# CITY OF ALBUQUERQUE

June 9, 2017

Site: Cosme Retail: 6205 Central Ave NW

## **Re: Drainage Ordinance (14-5-2-1) Violations for Erosion and Sediment Control**

DATE	REVISION	LOT C-151A, BLOCK 2, TOWN OF ALBUQUERQUE, BERNALILLO COUNTY, NEW MEXICO
		6205 CENTRAL AVE NW
		RETAIL SUITES
		Erosion & Sediment Control Plan

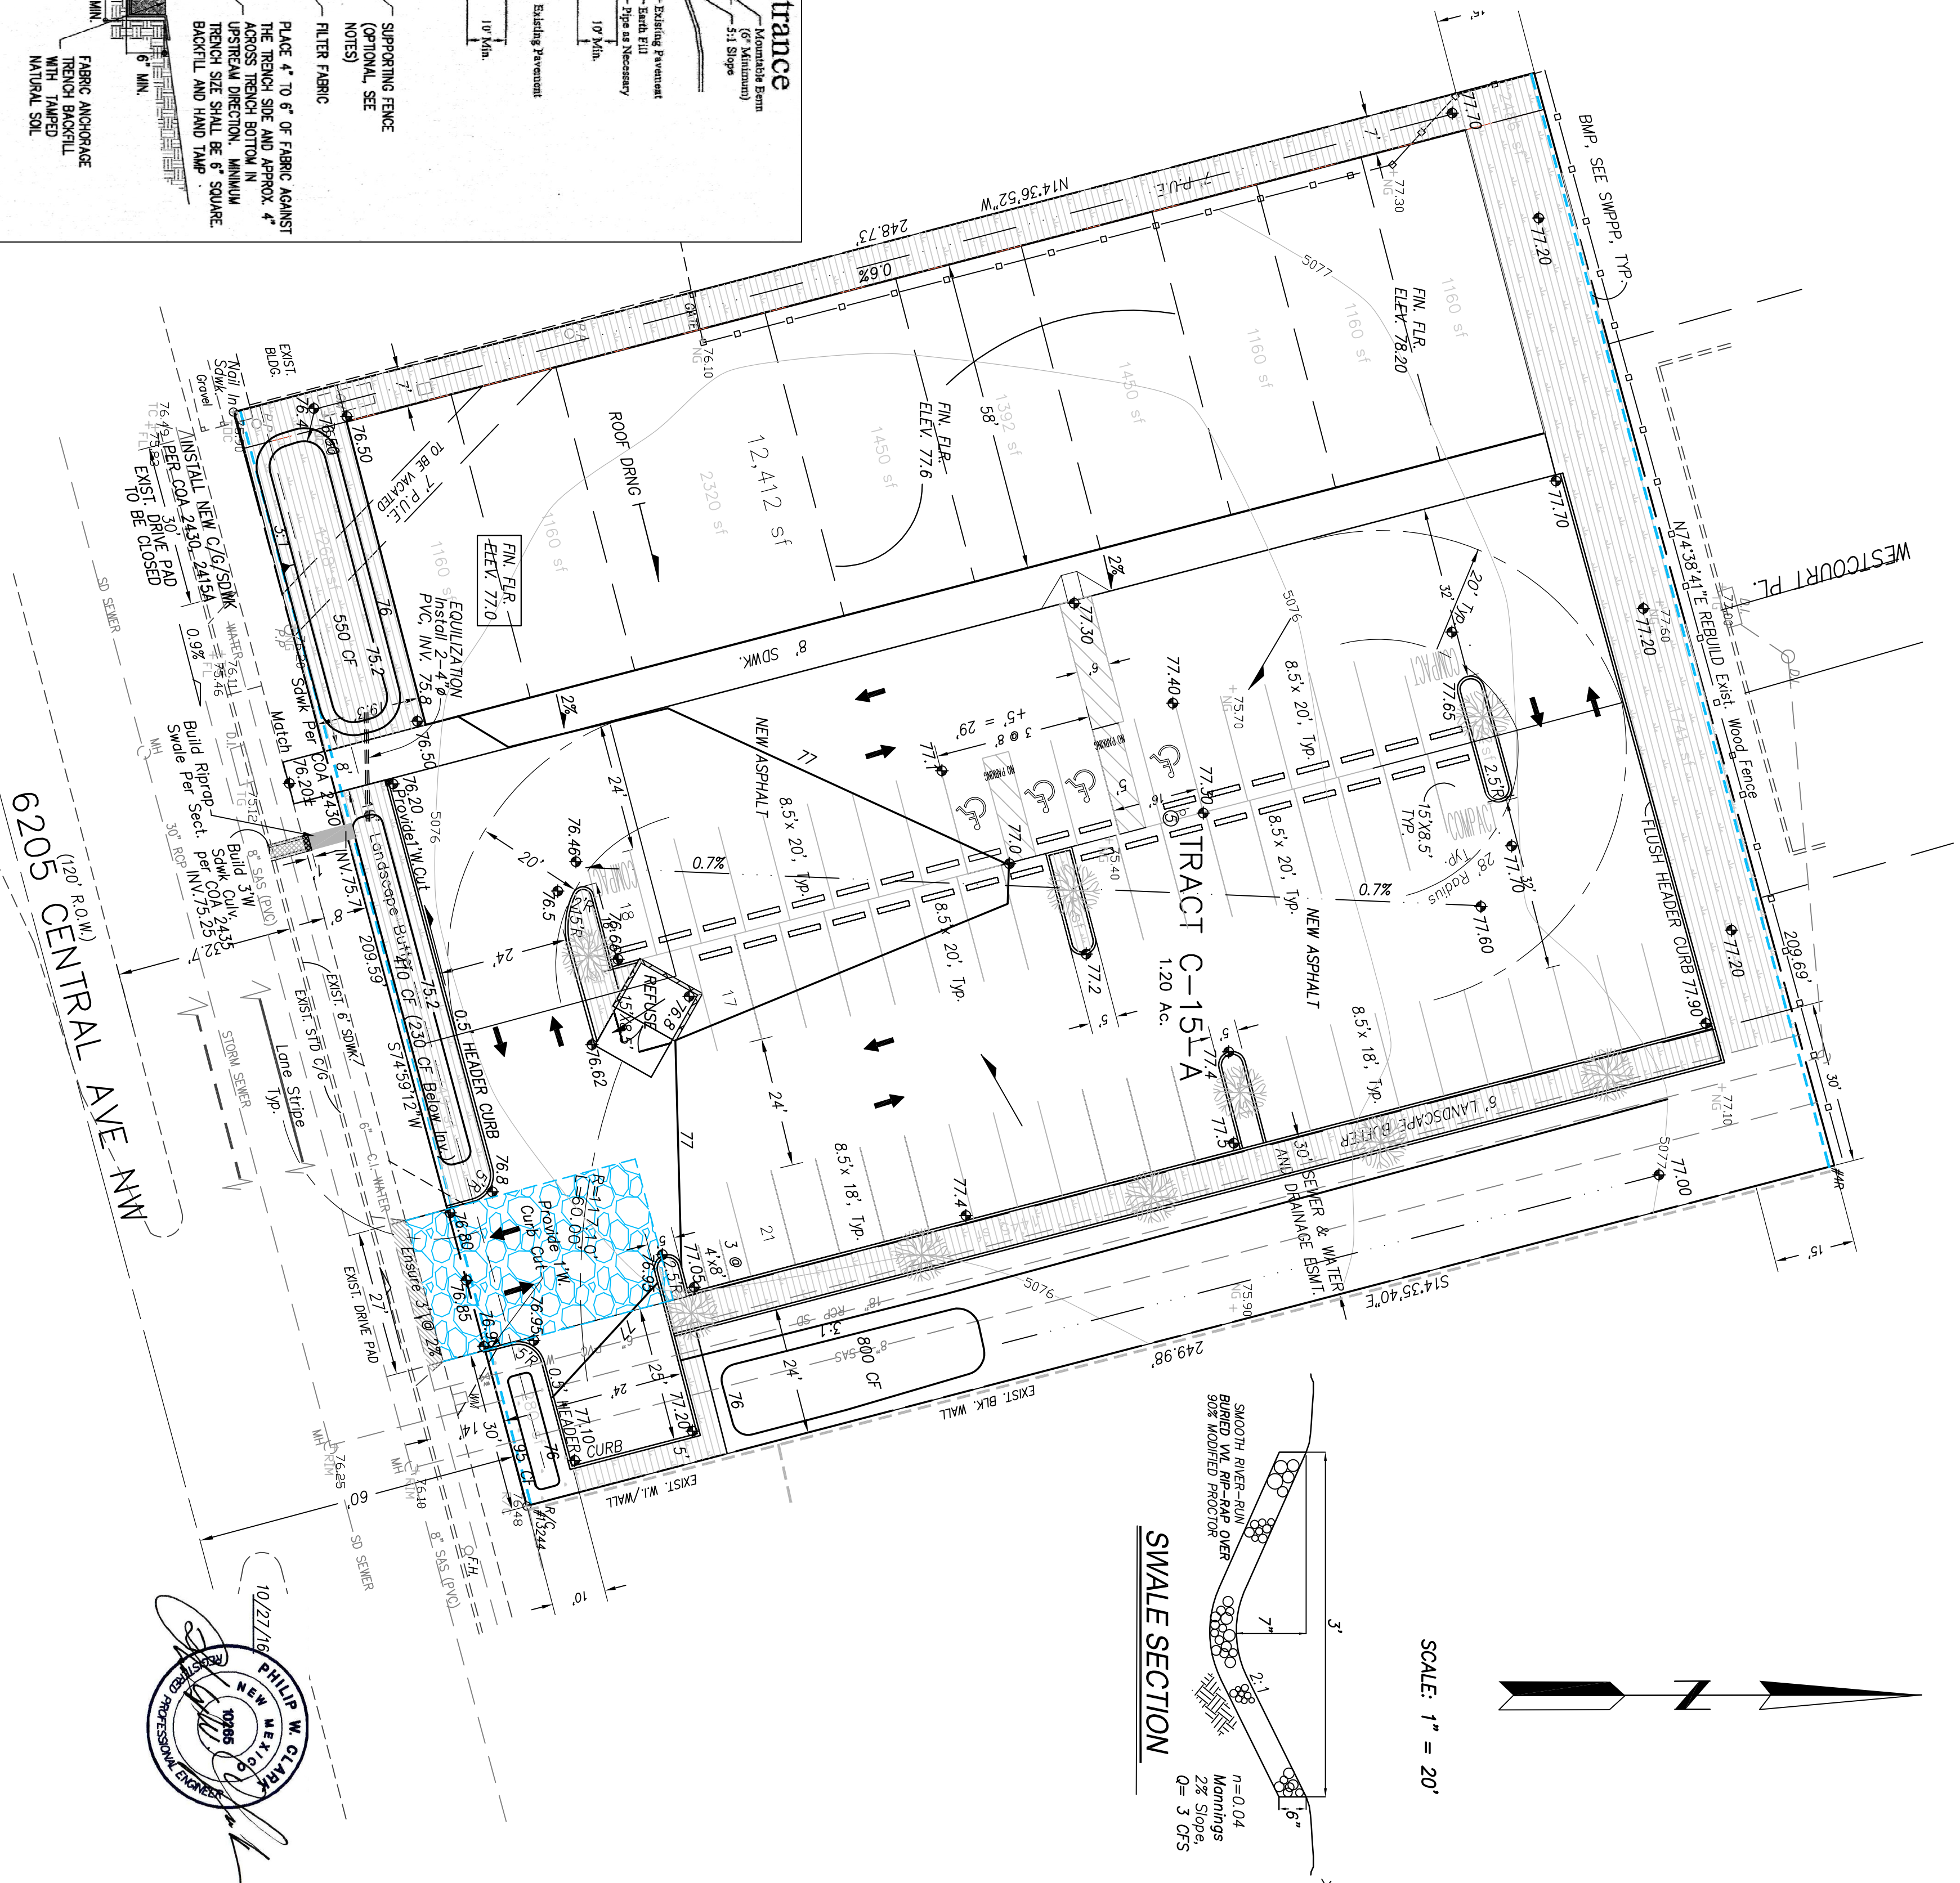
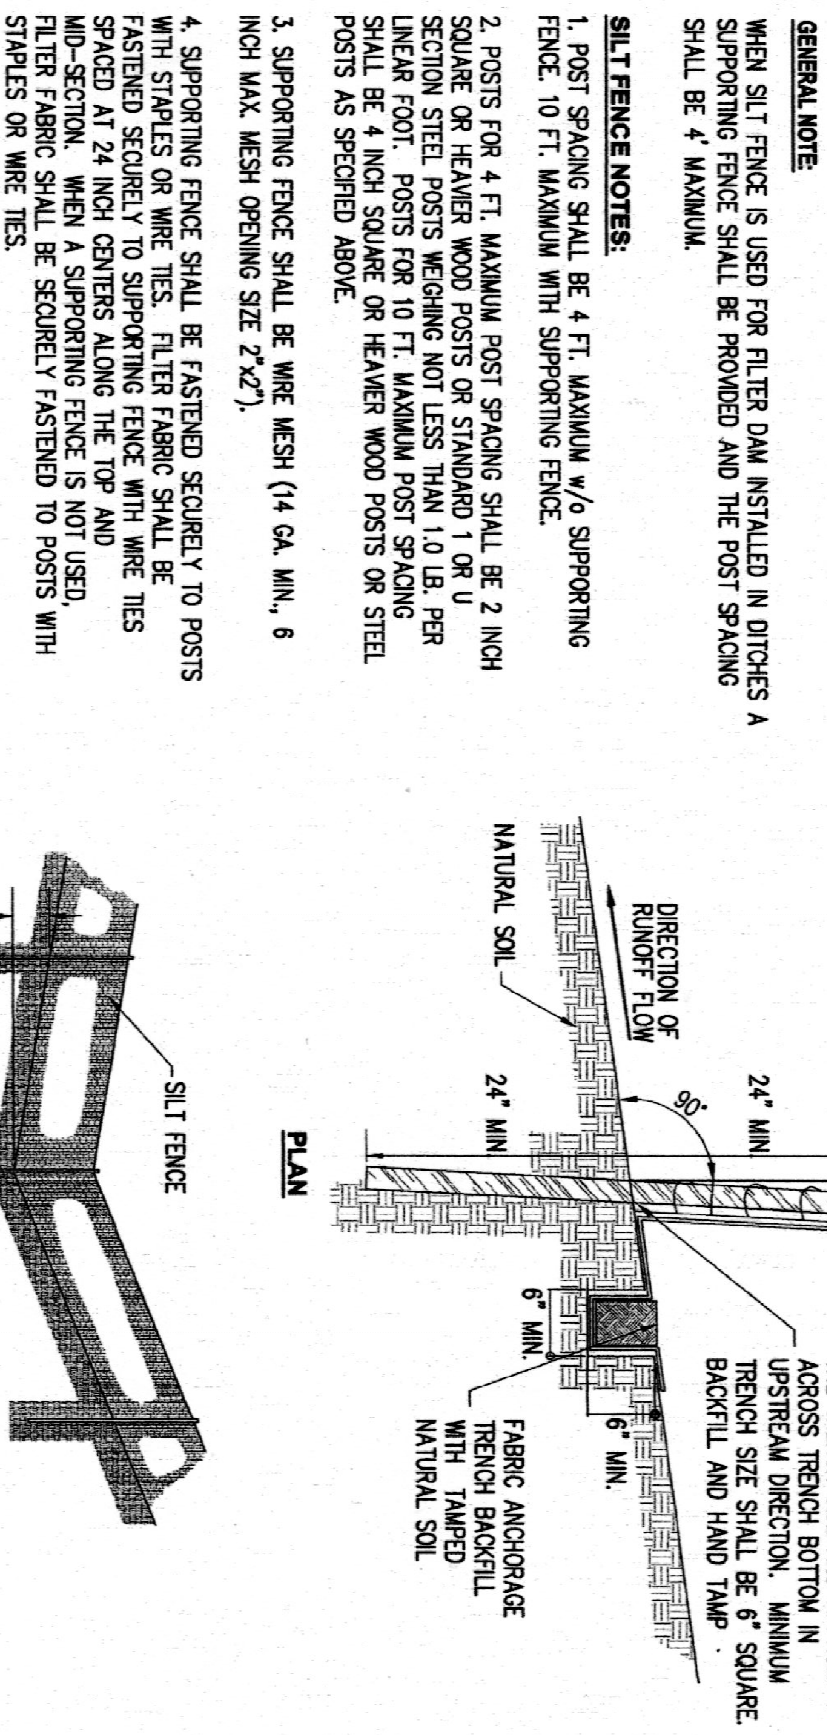
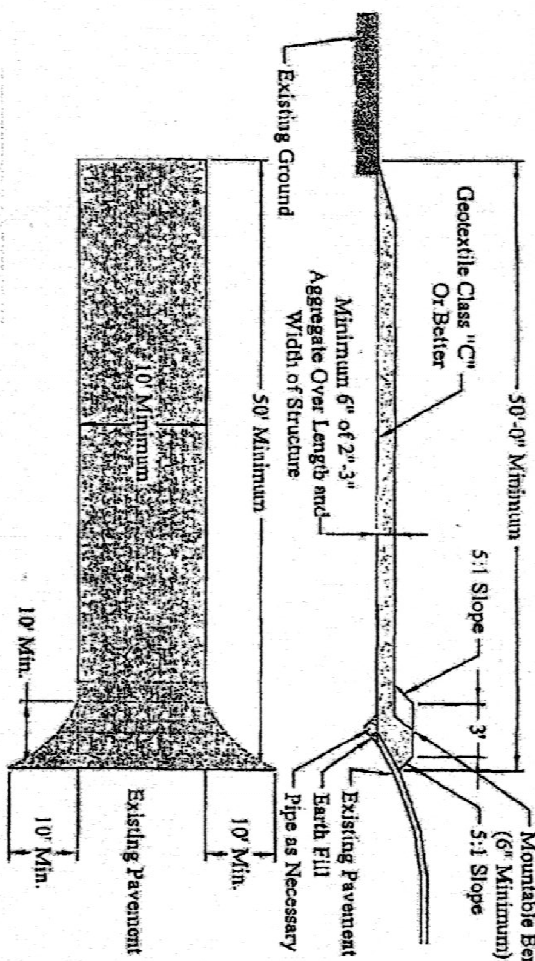
1. Along Central Ave, there was a missing section of silt fence and the silt fence that is installed is installed incorrectly.
2. There was windblown dirt in the gutter on Central Ave.
3. There was no stabilized construction entrance.
4. There was trash observed at the site.
5. There was a pile of dirt behind (West) the building and no sediment BMP to prevent the dirt from going into the adjoining property.

1. Properly install silt fence along Central Ave per the approved Erosion and Sediment Control plan.
2. Remove dirt from gutter on Central Ave. in front of the project.
3. Install a stabilized construction entrance per the approved Erosion and Sediment Control plan.
4. Remove trash.
5. Remove the pile of dirt behind (West) the building or provide a sediment BMP to prevent the dirt from going into the adjoining property.
